PLANNING BOARD REPORT PORTLAND, MAINE

New Yard at Canal Landing
Boatyard and Boat Repair Facility
40 West Commercial Street

Amendment to
Level III Site Plan, Conditional Use, Shoreland Zone, Flood Plain, Site Location of Development
New Yard, LLC, Applicant

Submitted to: Portland Planning Board: Public Hearing Date: October 22 2013 Project # 2013-224 Amending # 2012-575 & # 2013-201 CBL: 59-A-1,2,3,4,5,6,7,8,9,10,11,12	Prepared by: Bill Needelman, Senior Planner Date: August 17,2013 Planning Board Report Number: #45-13
--	---

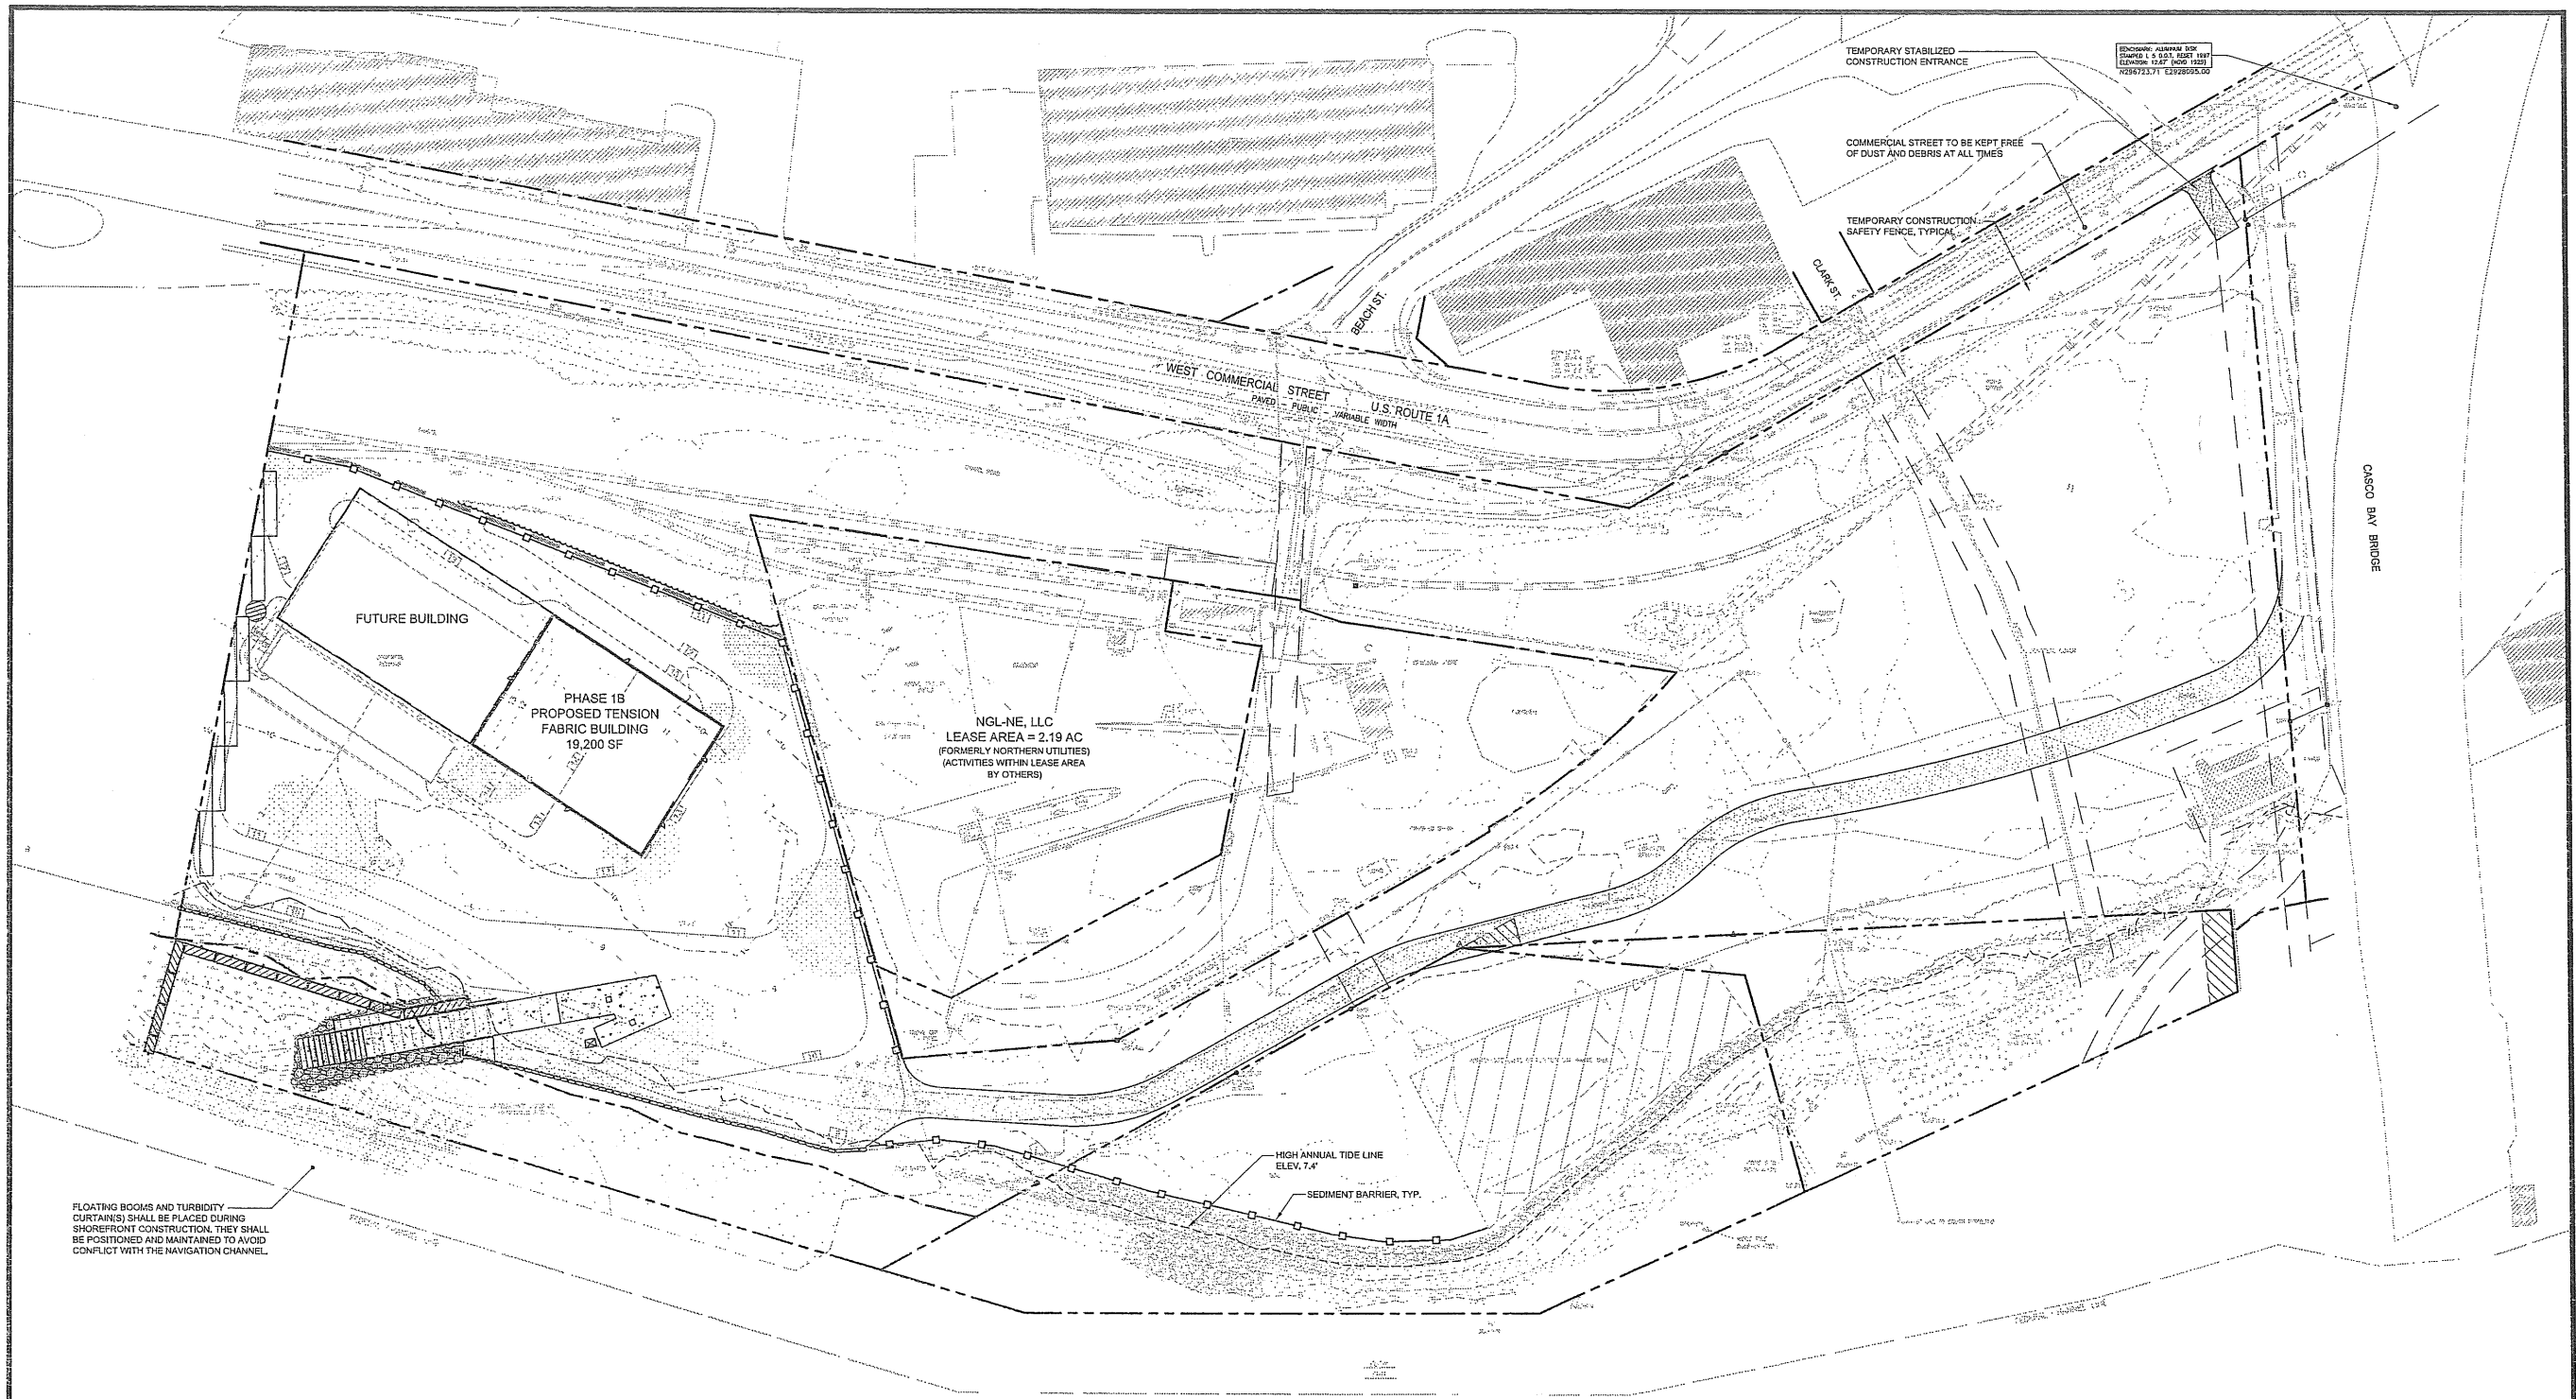
The site is currently served by two fire hydrants on West Commercial Street and an additional hydrant in the interior of the site. The proposed utility plan, Attachment P10, (excerpted above) shows additional hydrant locations within blue buffer circles.

PROJECT: CANAL LANDING (PHASE 1A)  
 TITLE: FIRE PROTECTION PLAN PHASE 1A ONLY  
 CLIENT: NEW YARD LLC  
 58 FORE STREET  
 PORTLAND, ME 04101

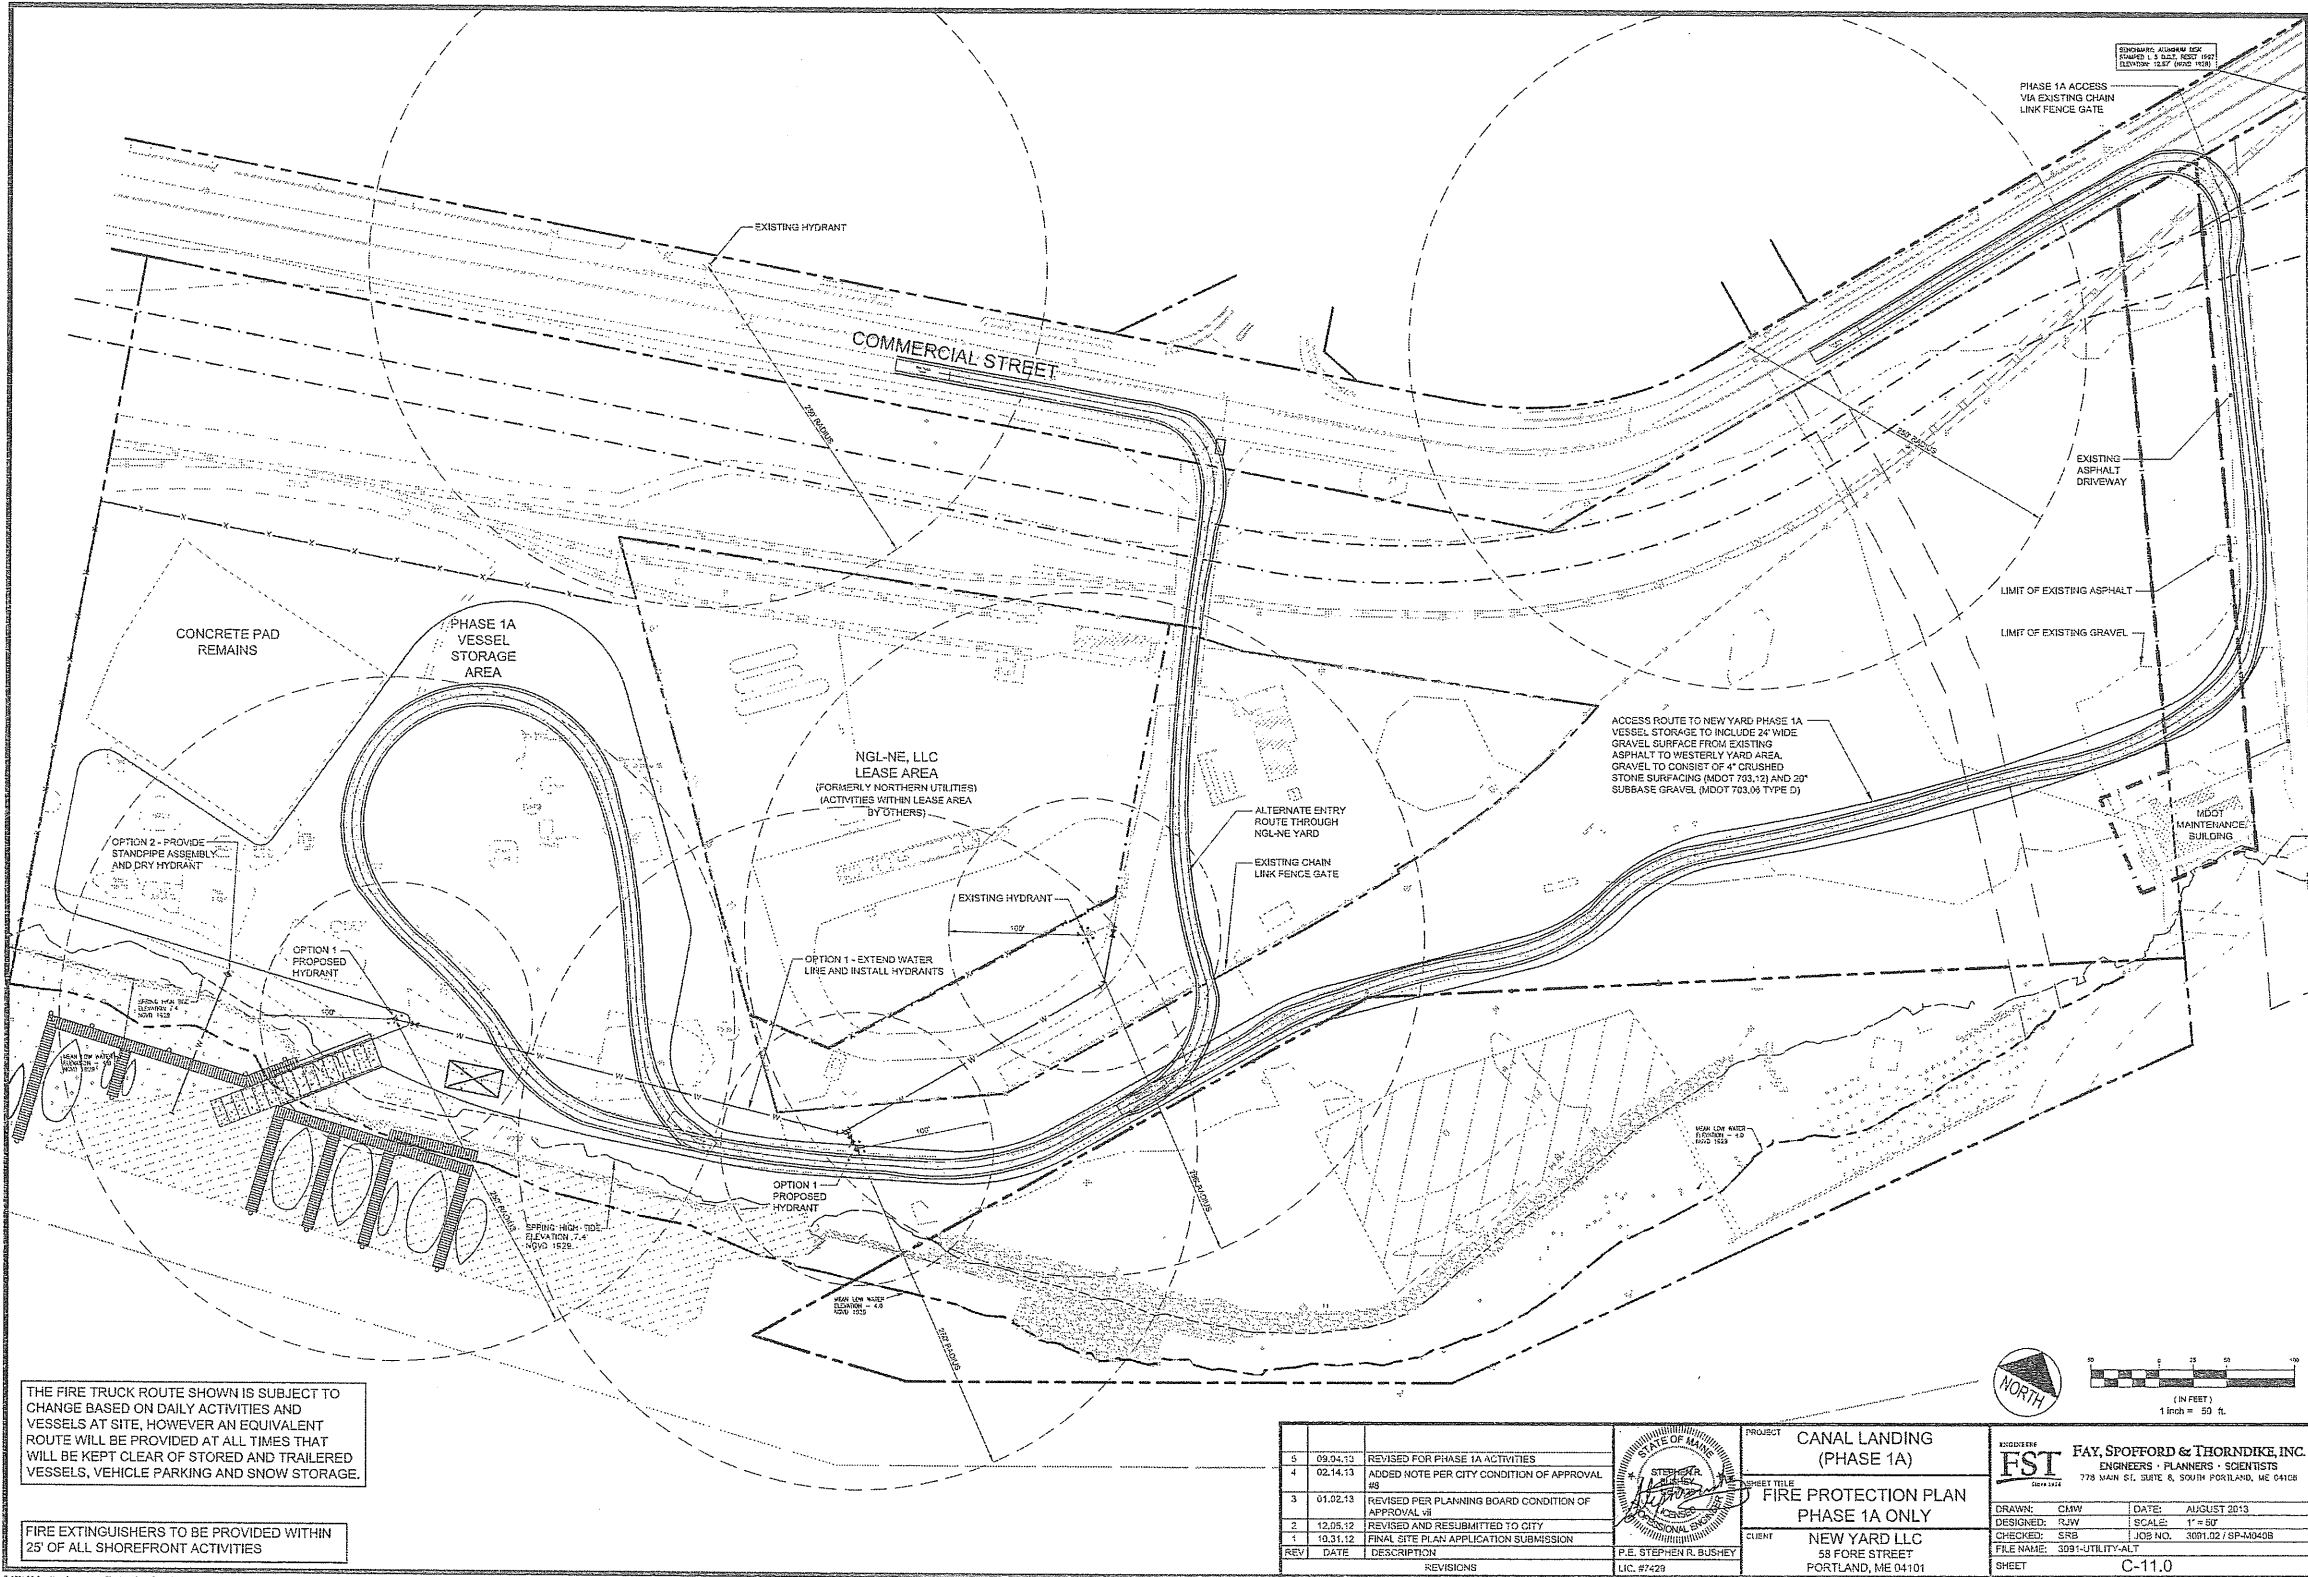
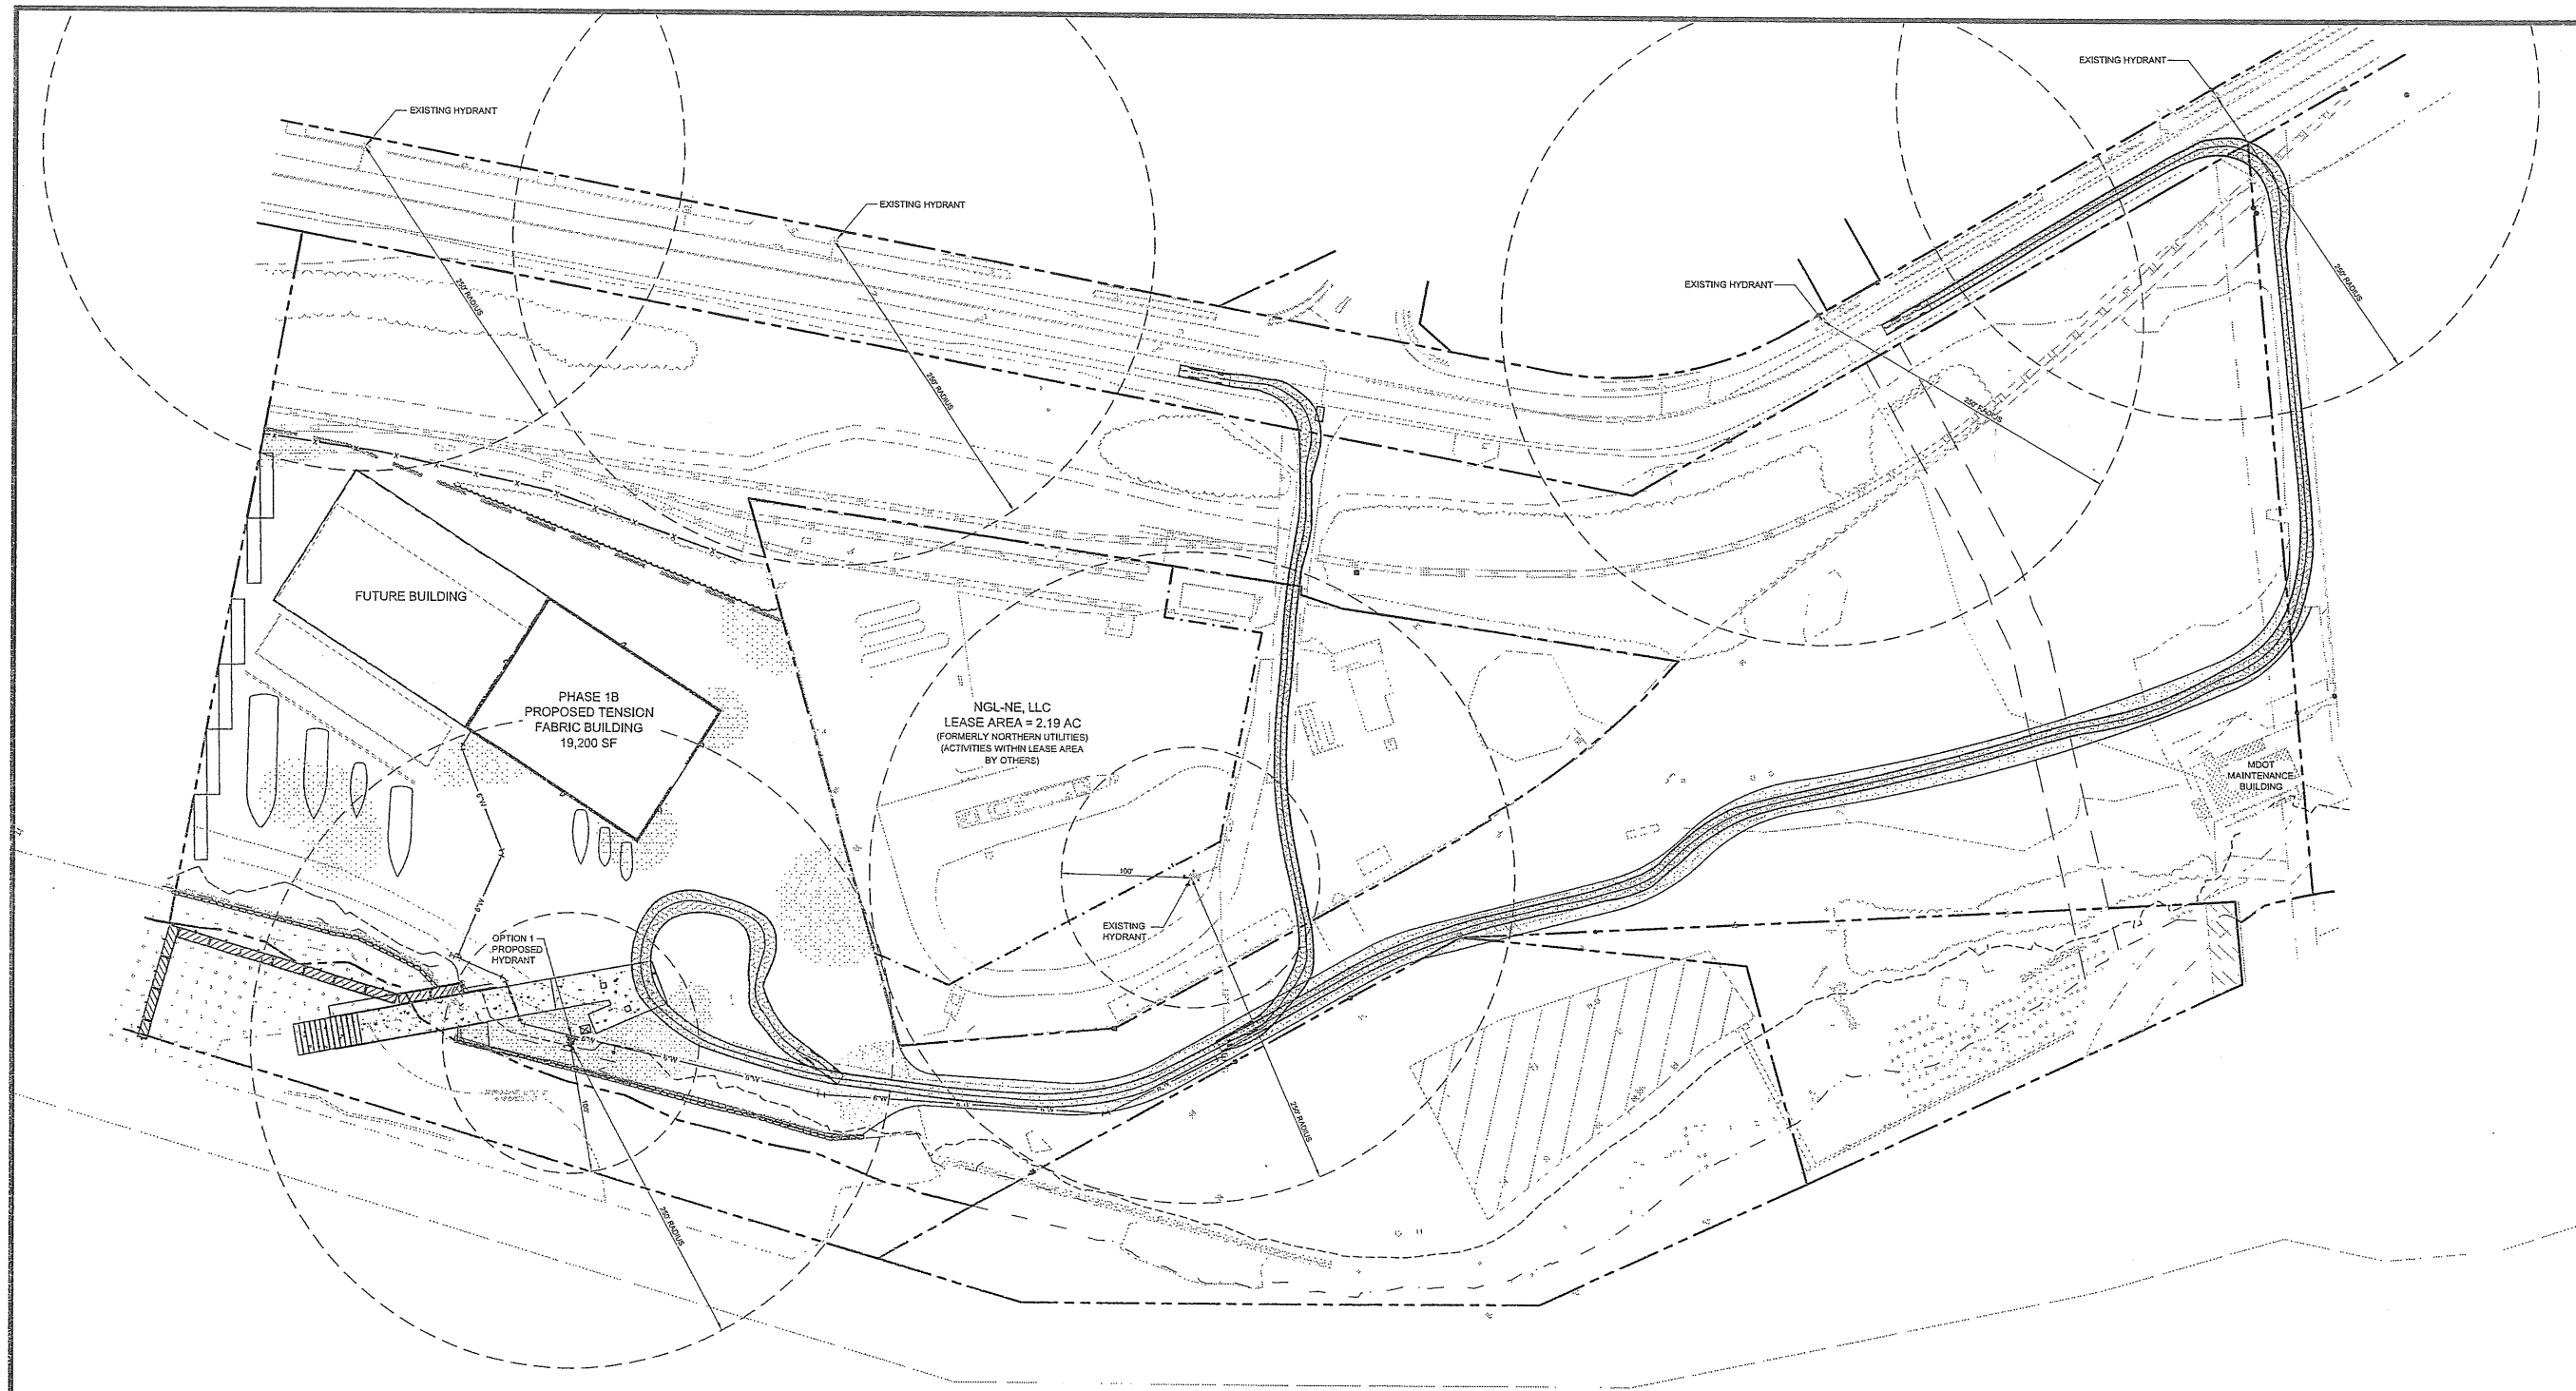
The applicant provided a revised fire access and circulation plan. Fire Safety reviewer, Captain Chris Pirone has not had opportunity to review the plan and a condition of approval is suggest that modifications to this plan may be needed pending further review.

With the proposed amendments, this plan will need to be updated and a condition of approval is suggested. The intent of the fire safety plan is to identify emergency access routes and their adequacy for supporting fire suppression equipment.
